## Inspector's Report

### ABP-321255-24

<b>Development</b>	Ballinclare Quarry, Proposed Material Recovery / Recycling Facility and Inert Landfill
<b>Location</b>	In the townlands of Ballinclare and Carrigmore, near Kilbride, Co. Wicklow
<b>Planning Authority</b>	Wicklow County Council
<b>Applicant(s)</b>	Kilsaran Concrete Unlimited Company
<b>Type of Application</b>	Application for approval Permission under 37E of the Planning and Development Act 2000, as amended
<b>Prescribed Bodies</b>	Development Applications Unit. Eastern Midlands Connacht Ulster and Southern Regional Waste Management Planning Offices. Geological Survey of Ireland. Health Services Executive.

NORTH

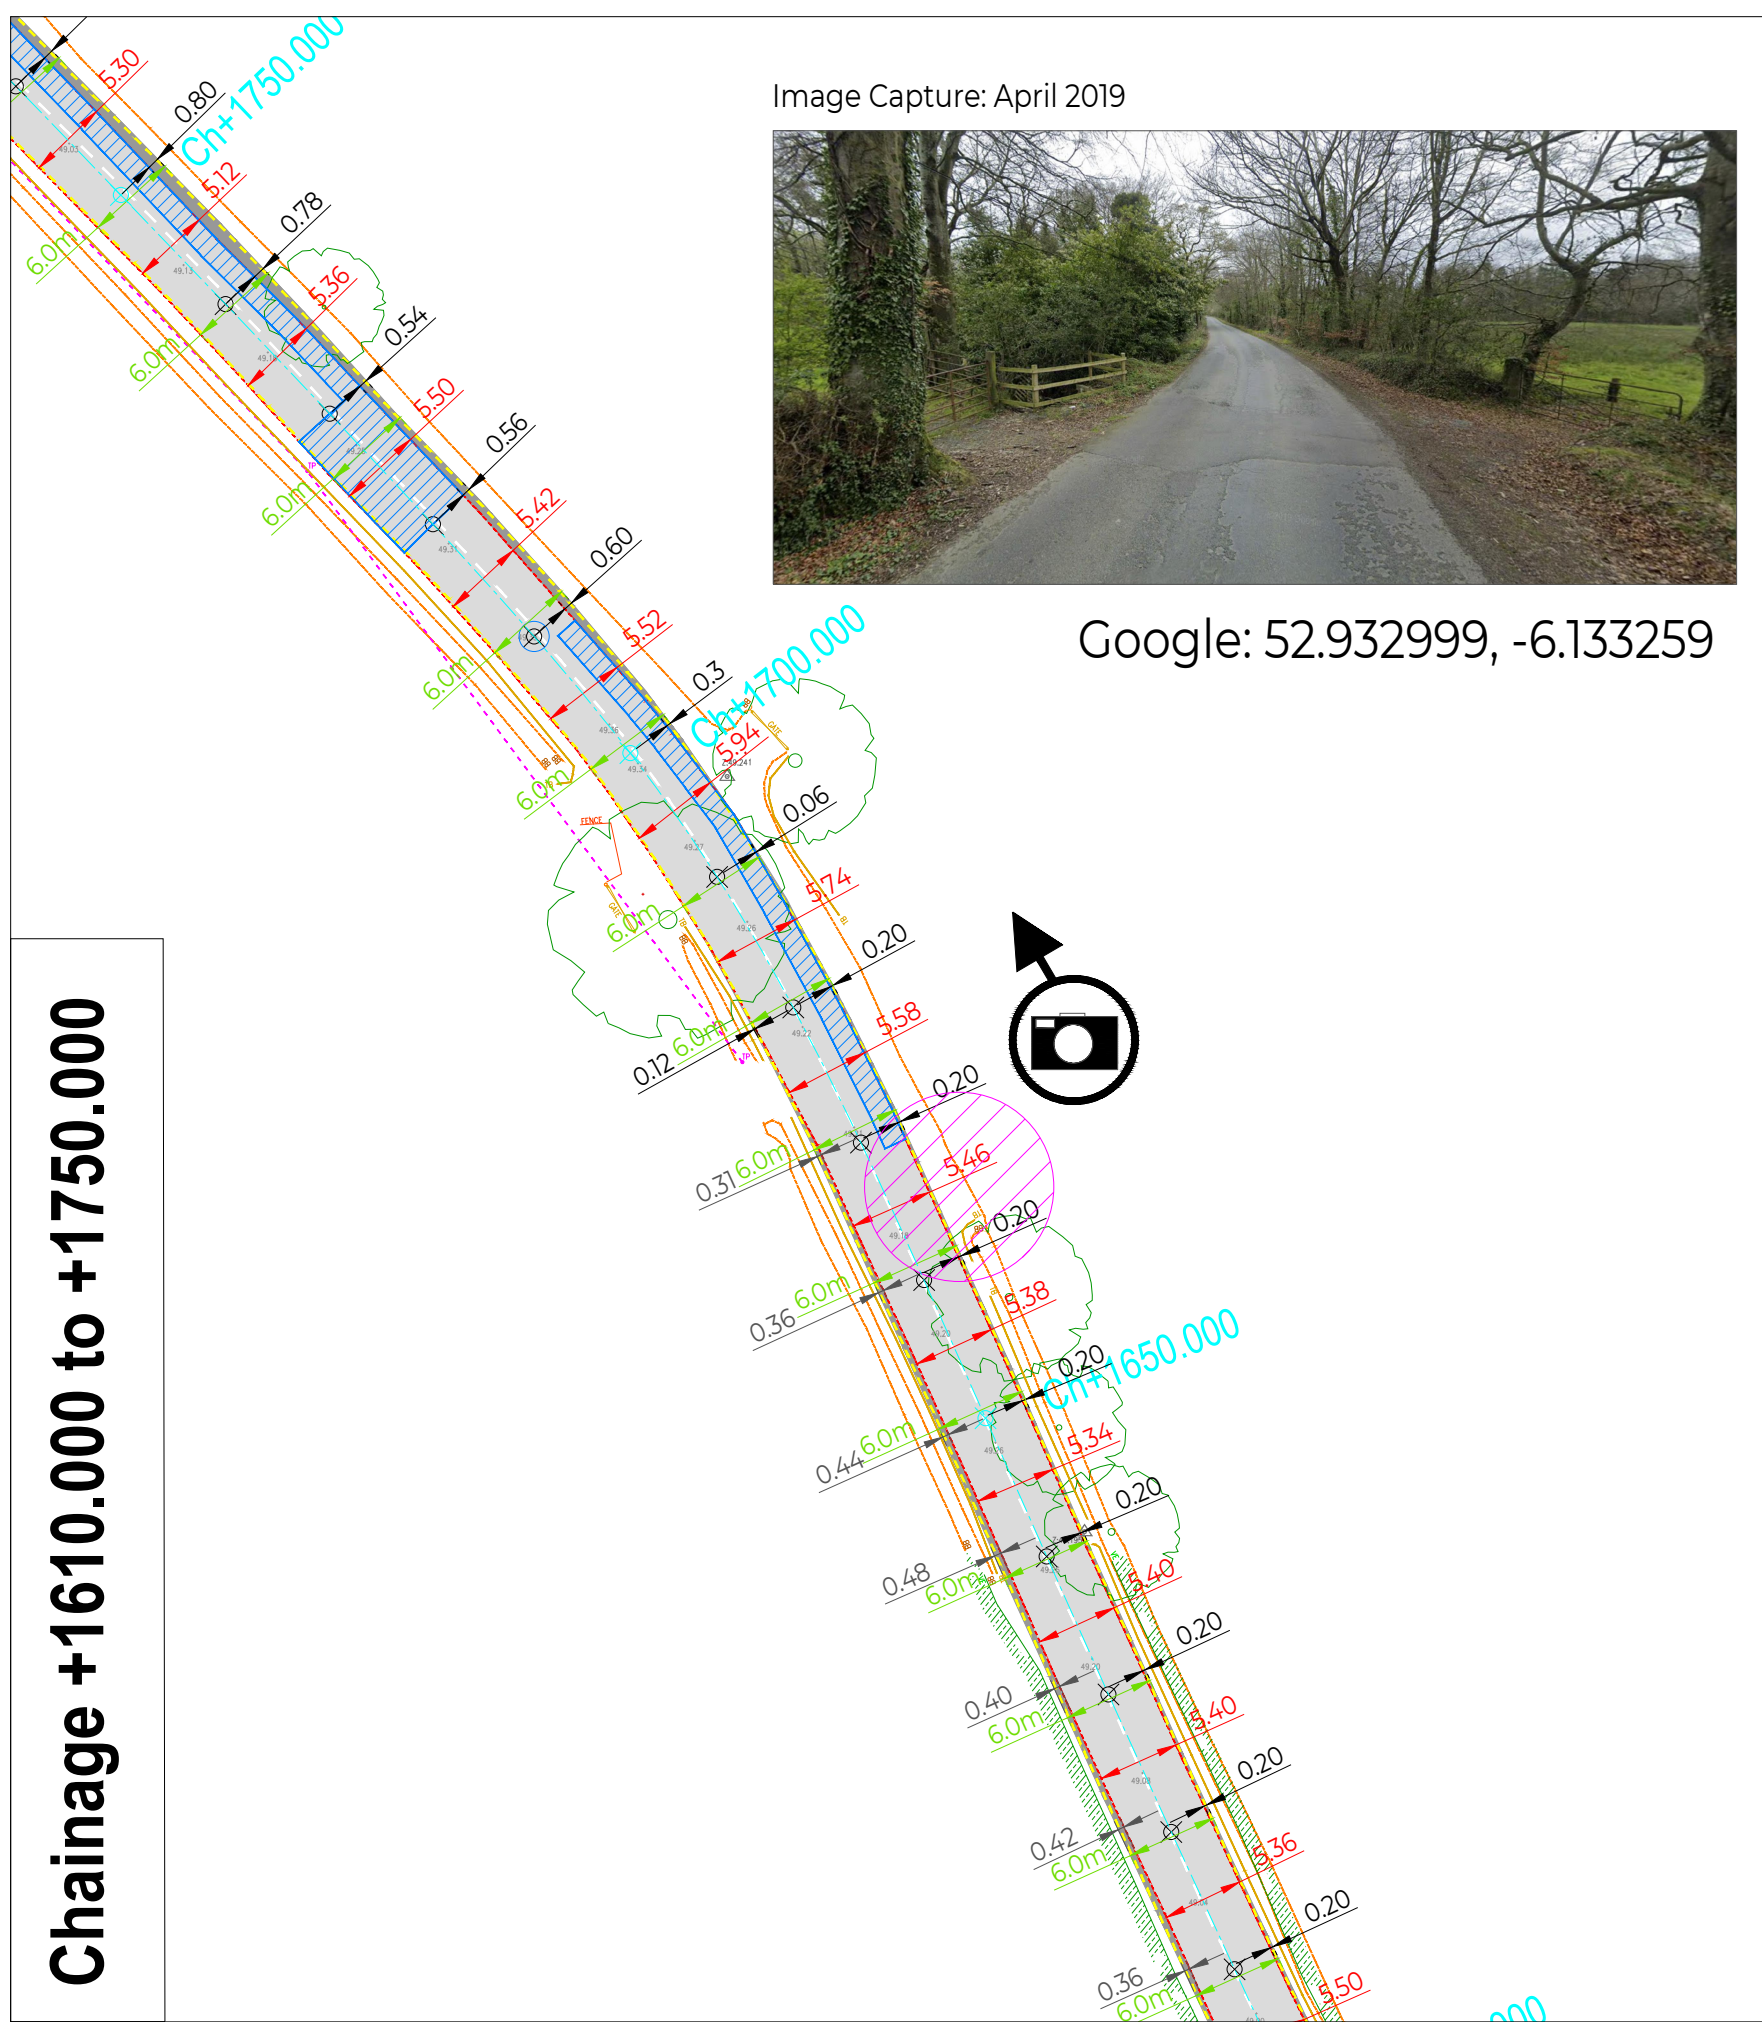
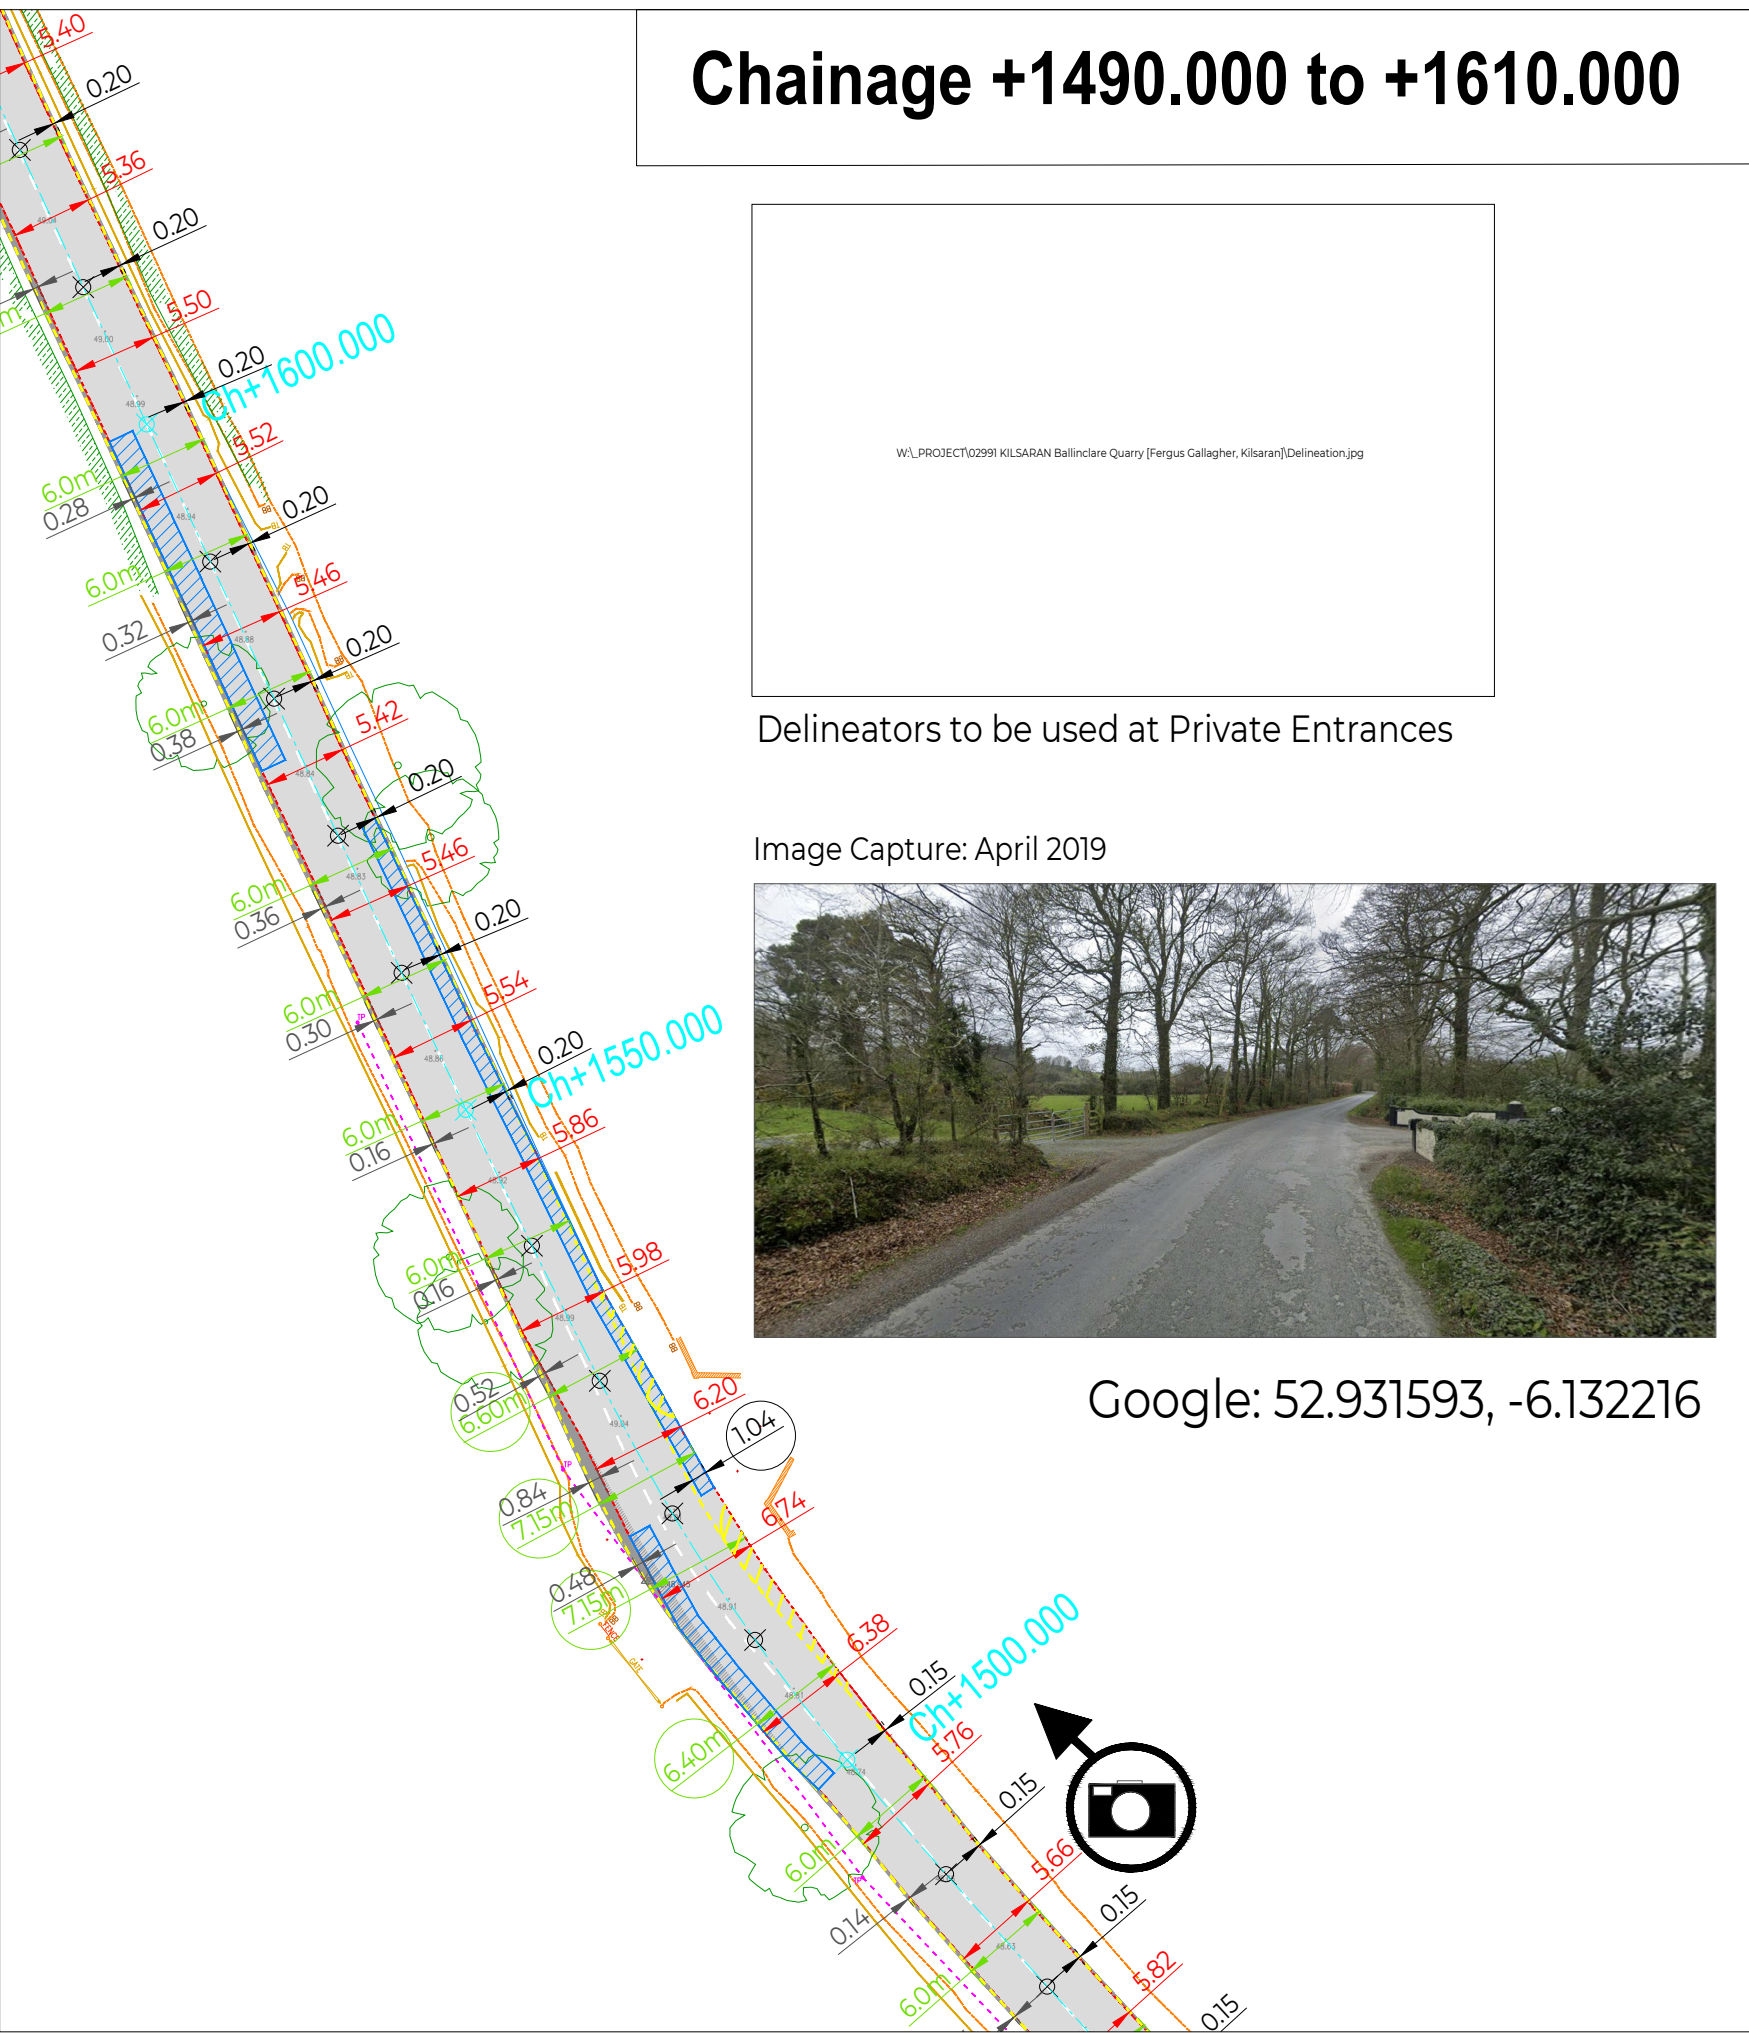
- Recommend a condition that the developer submit appropriate plans and details for the proposed road strengthening works on Local Road L1157 associated with M11 overpass 'Eirspan Structure no: BM-M11-046.00.' The plans and details shall demonstrate compliance with TII Publications and shall also ensure the 5.3m clearance shall be maintained over the extents of the new road layout on the Local Road L1157.
